**From:** Kaycee Hathaway  
**Sent:** Tuesday, April 22, 2014 2:16 PM  
**To:** 'bcnw@hughes.net'  
**Cc:** cruseandassoc@kvalley.com  
**Subject:** Preliminary Approval: BL-13-00032 Dunning  
**Attachments:** BL-13-00032 Dunning Preliminary Approval Signed.pdf; BL-13-00032 Dunning PW Final.pdf; BL-13-00032 Dunning Comments FM.pdf

RE: Dunning Boundary Line Adjustment (BL-13-00032),

TO: Kaycee Hathaway, CDS  
FROM: Christina Wollman, Planner III  
DATE: April 15, 2014  
SUBJECT: Dunning BL-13-00032

DUNNING PROPERTY  
PORTIONS OF SECTIONS 18, 19, AND 20,  
ALL IN T. 19 N., R. 19 E., W.M.

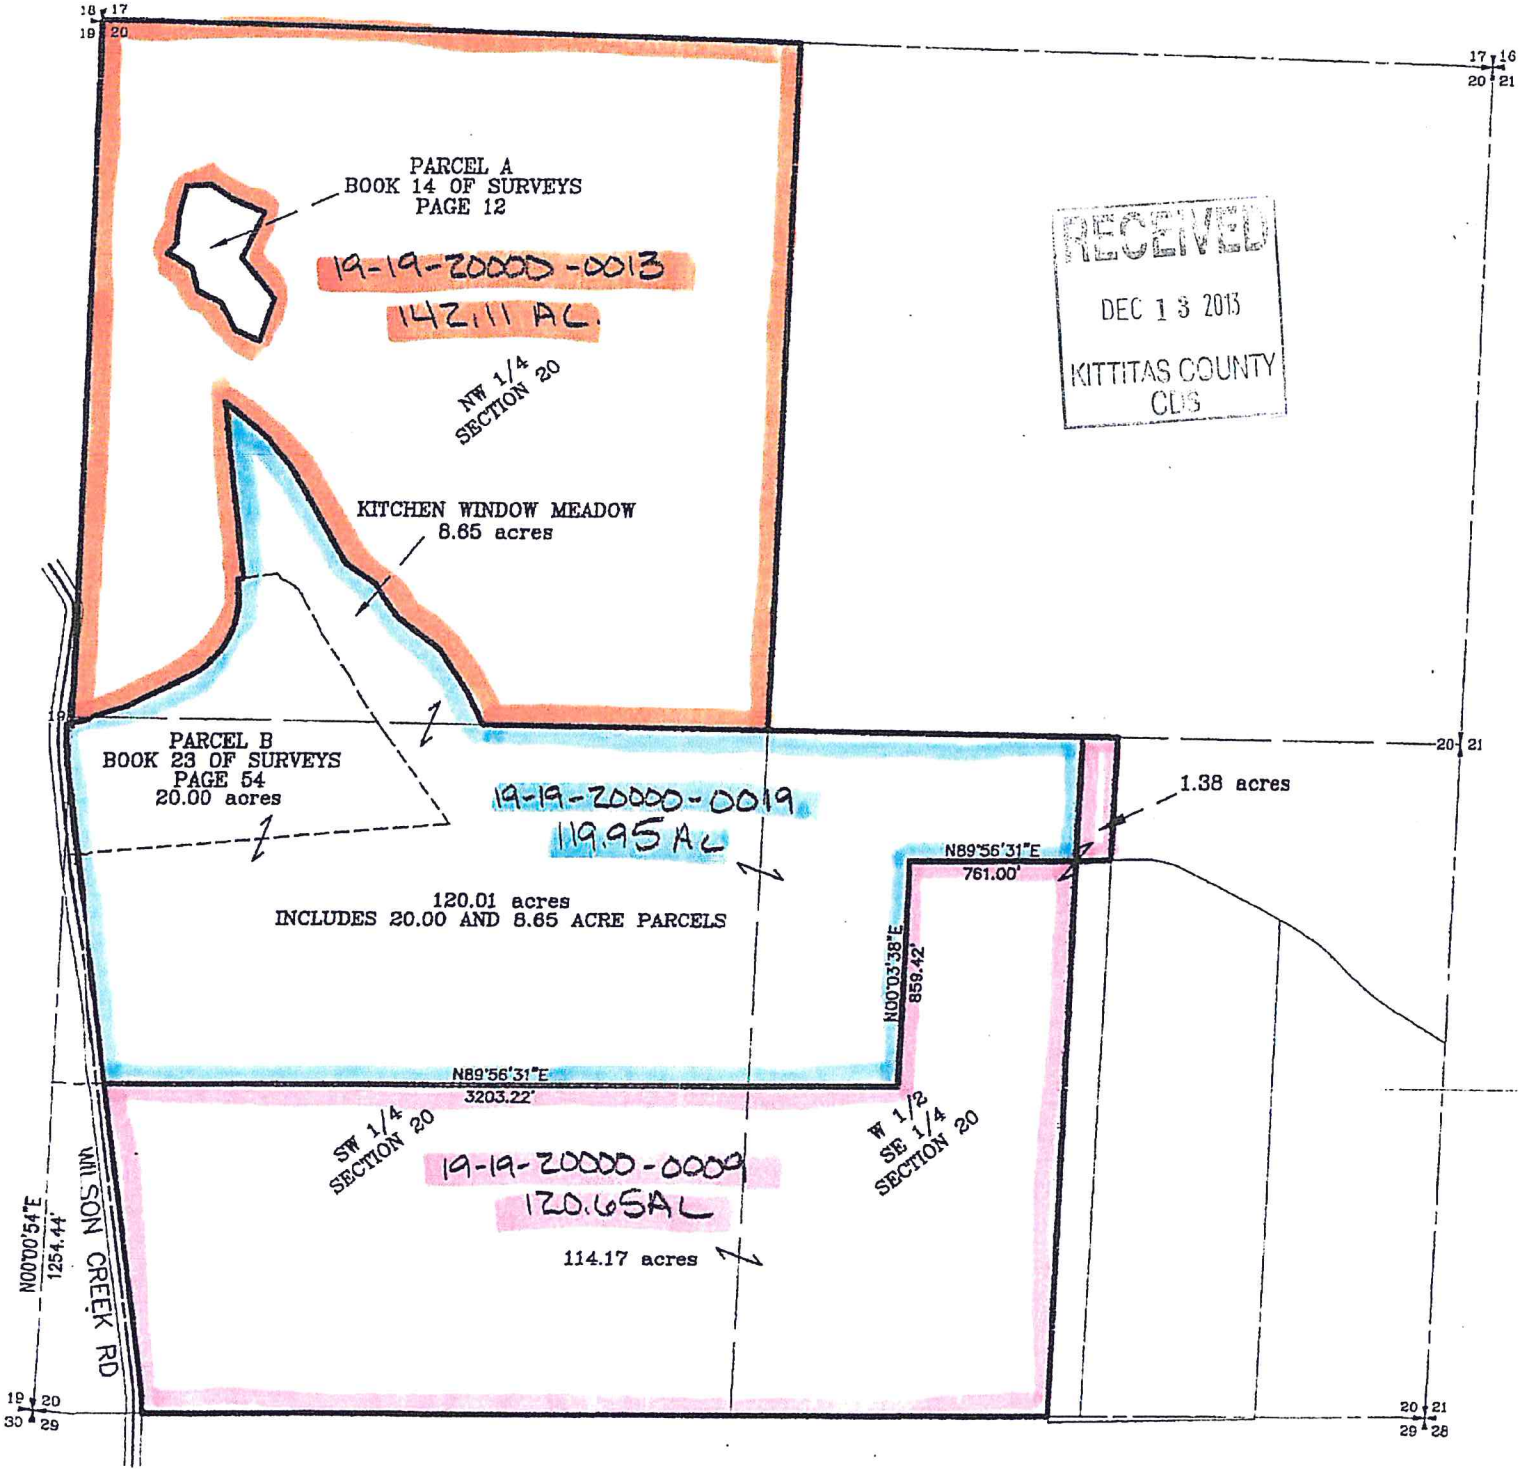
In Section 18, where is the land that lies east of Wilson Creek Road going? It's shown in yellow on the attachment.

258334/19-19-18000-0004

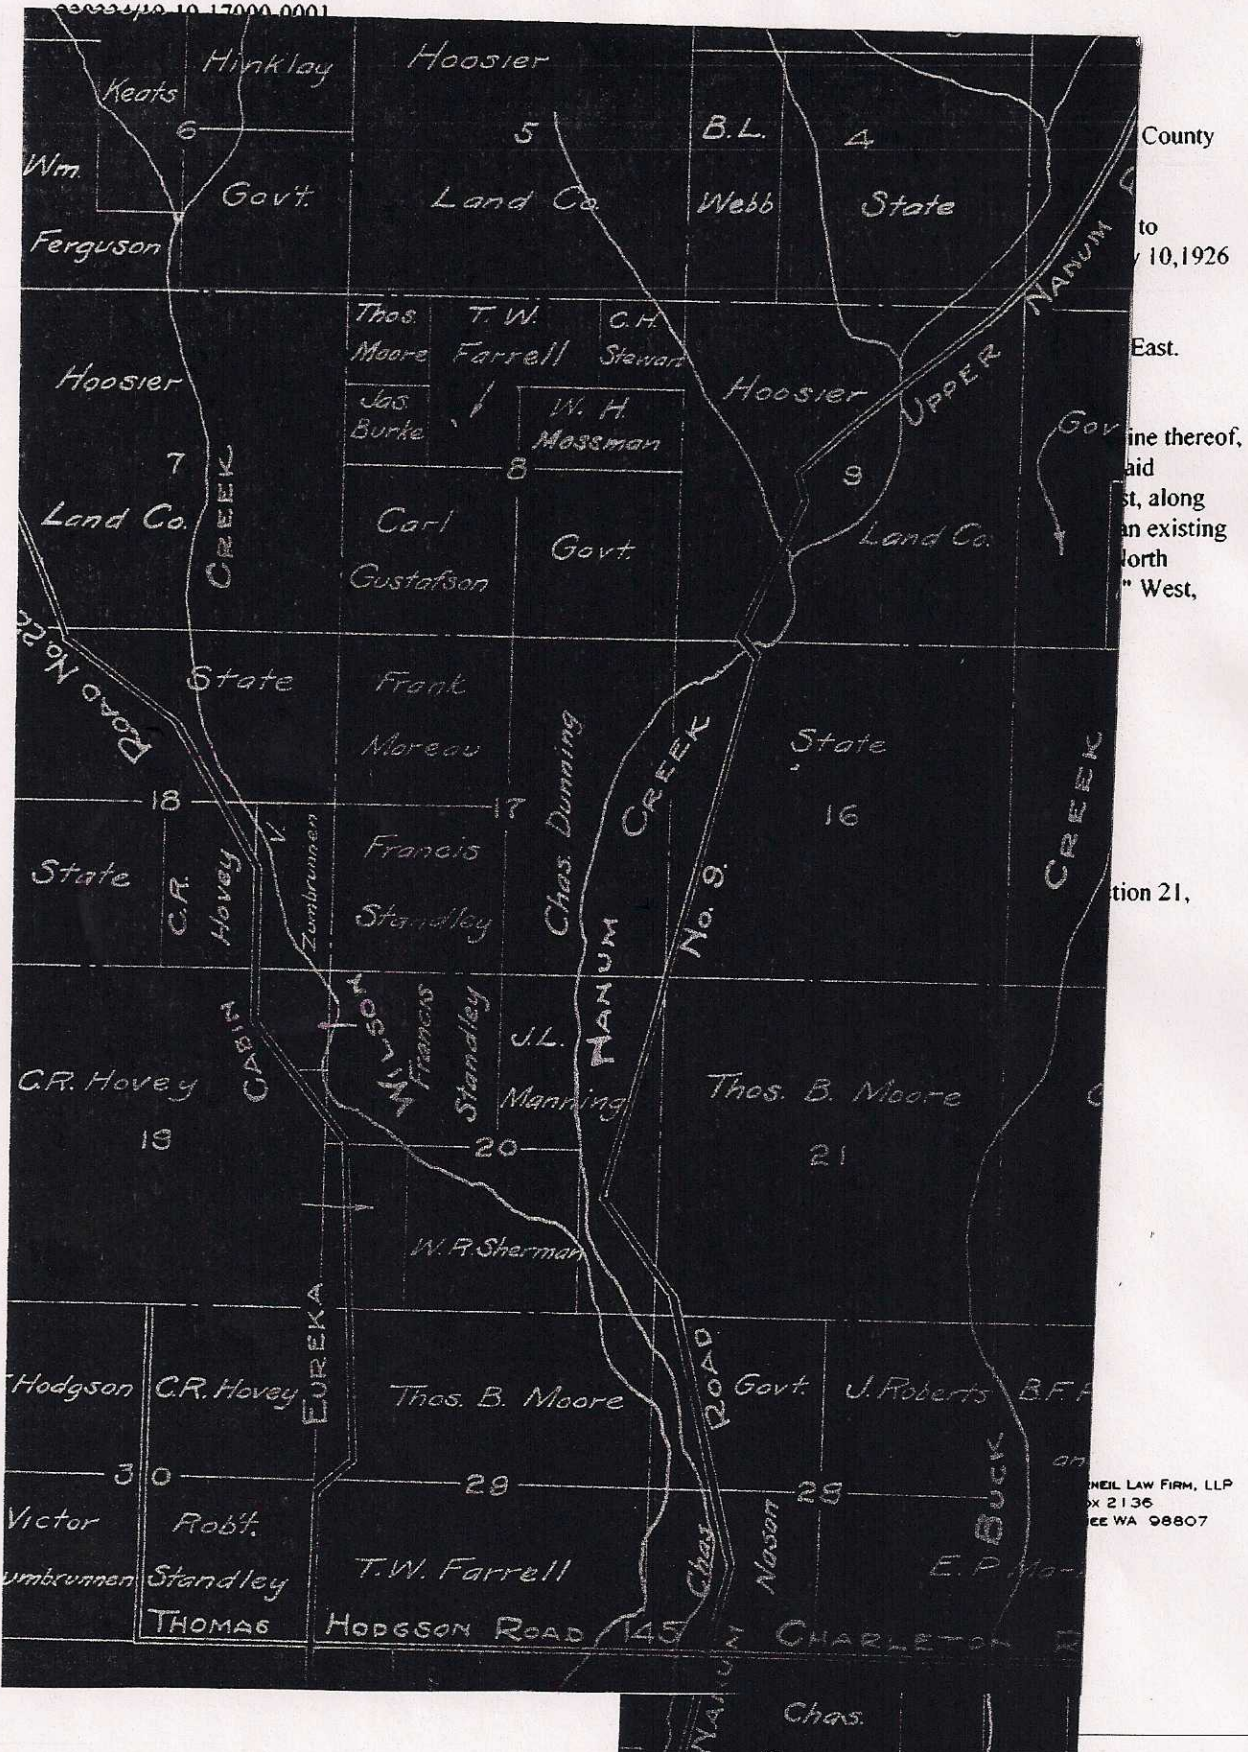
Is the road supposed to be the parcel line but our parcel map is drawn incorrectly? It appears so from reading the assessor's legal descriptions.
